61-79 Hall Street, Bondi Beach

MP09_0081 MOD 4 – Internal and external design changes and amendment to a condition relating to public art

Director-General's
Environmental Assessment Report
Section 75W of the
Environmental Planning and Assessment Act 1979

July 2012

Landscape Design Application

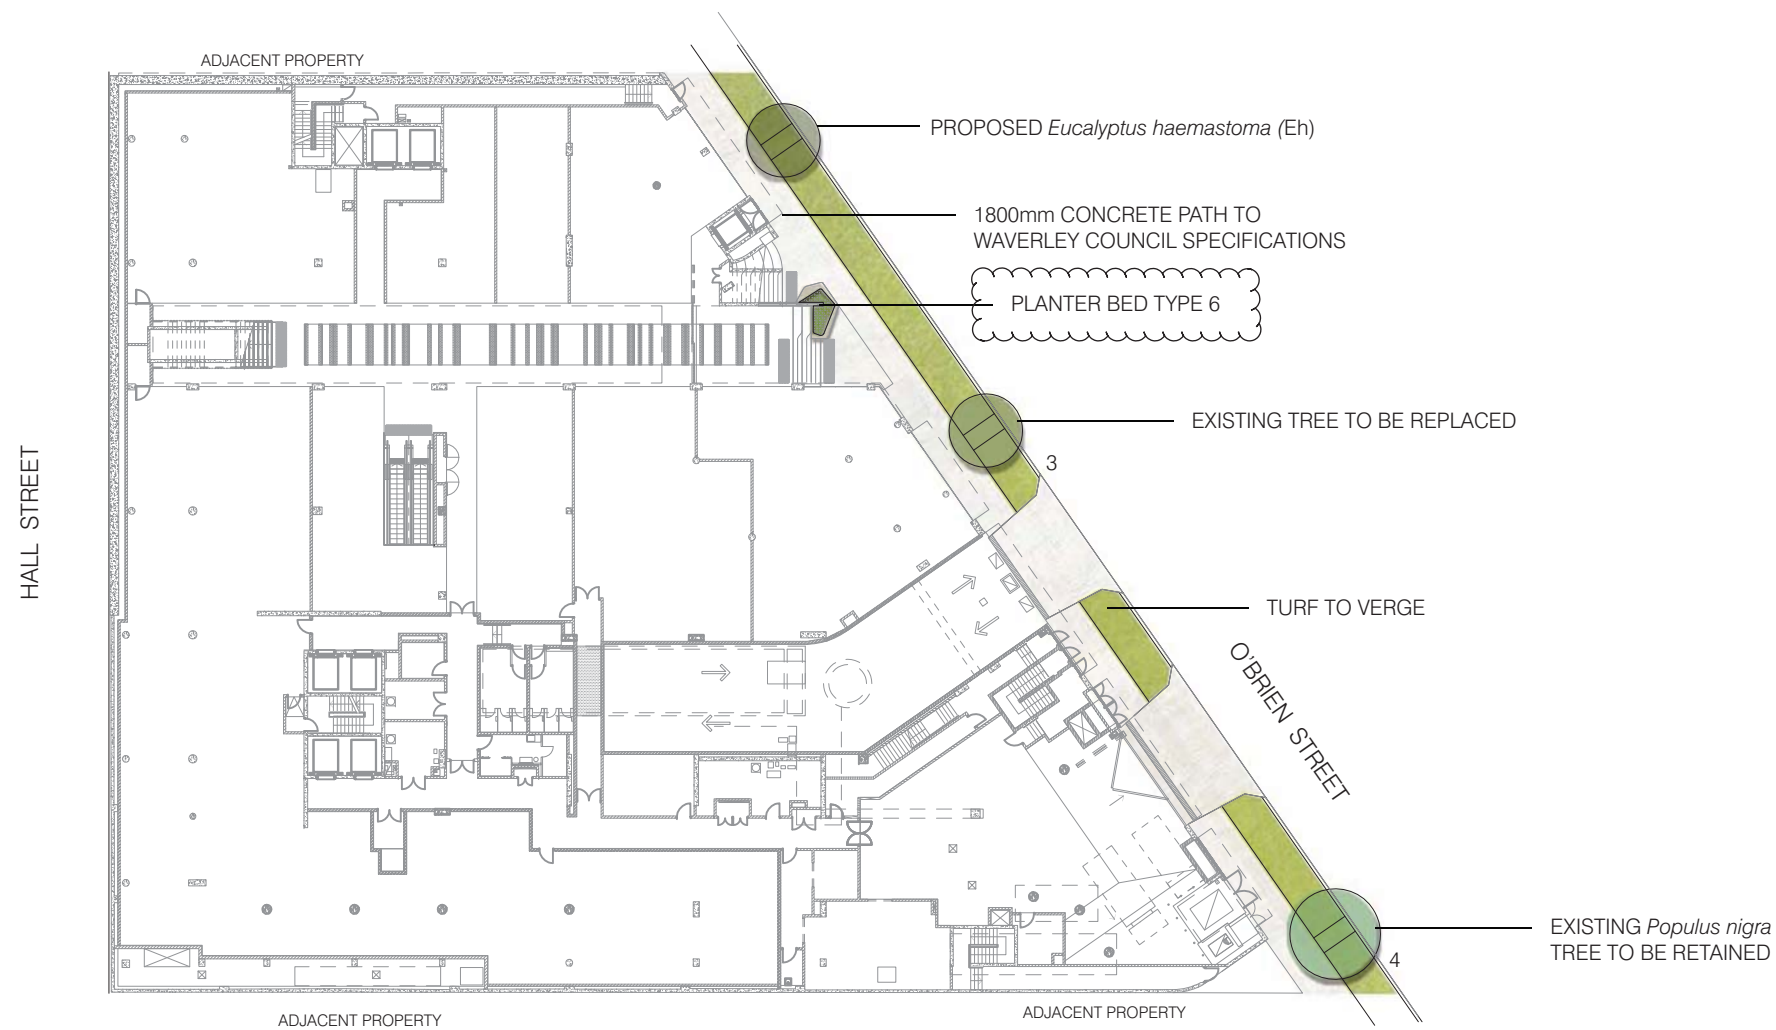
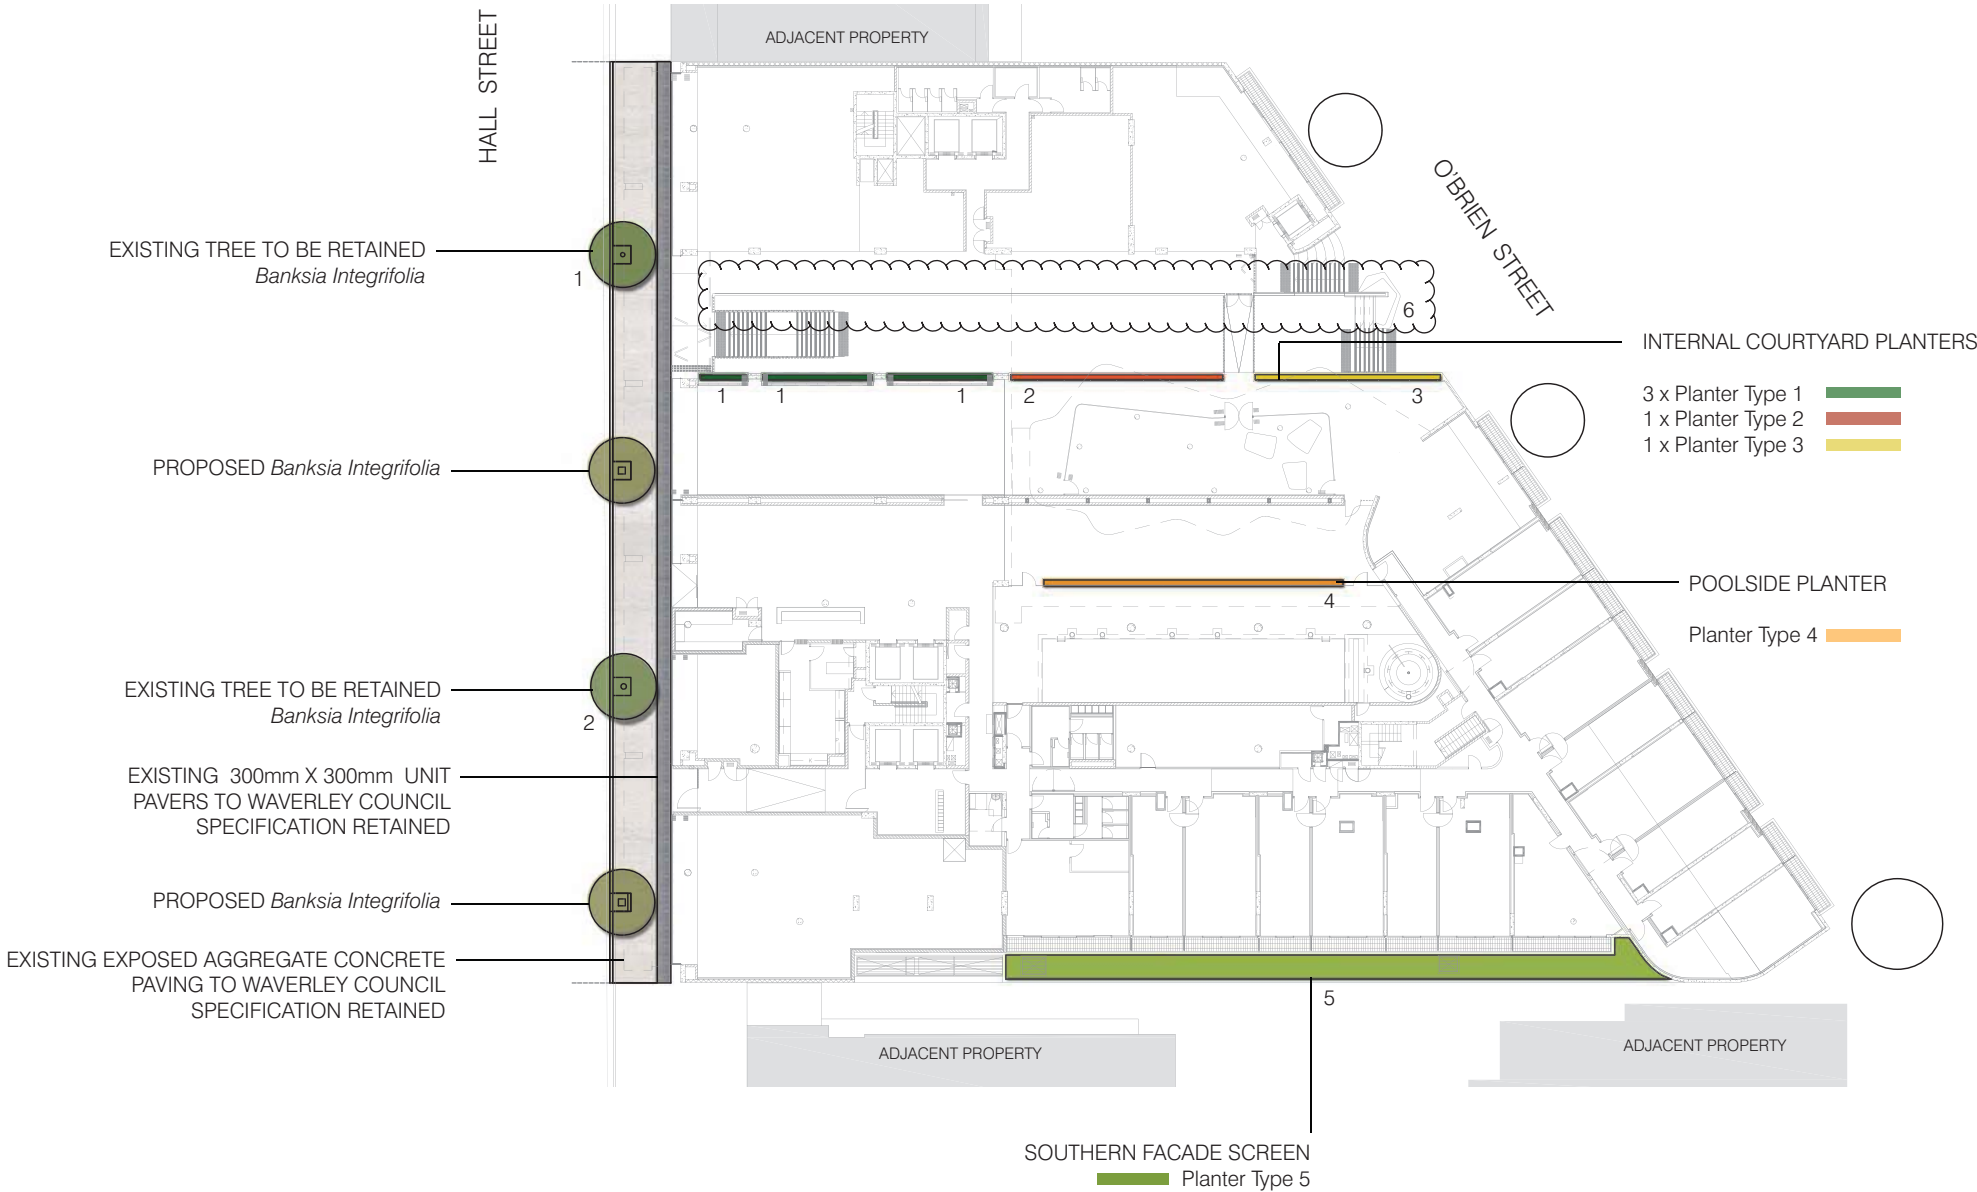
The submitted Landscape Plan proposes street tree planting along Hall Street. It also indicates that the two existing trees along Hall Street may require removal as they do not allow for a clear stem height above the proposed architectural awning.

The department notes that the location of street trees do not fall within the site's boundary. Consequently, any street tree designs and street tree removal require council's approval, and a separate application to council will be required for the removal of the trees.
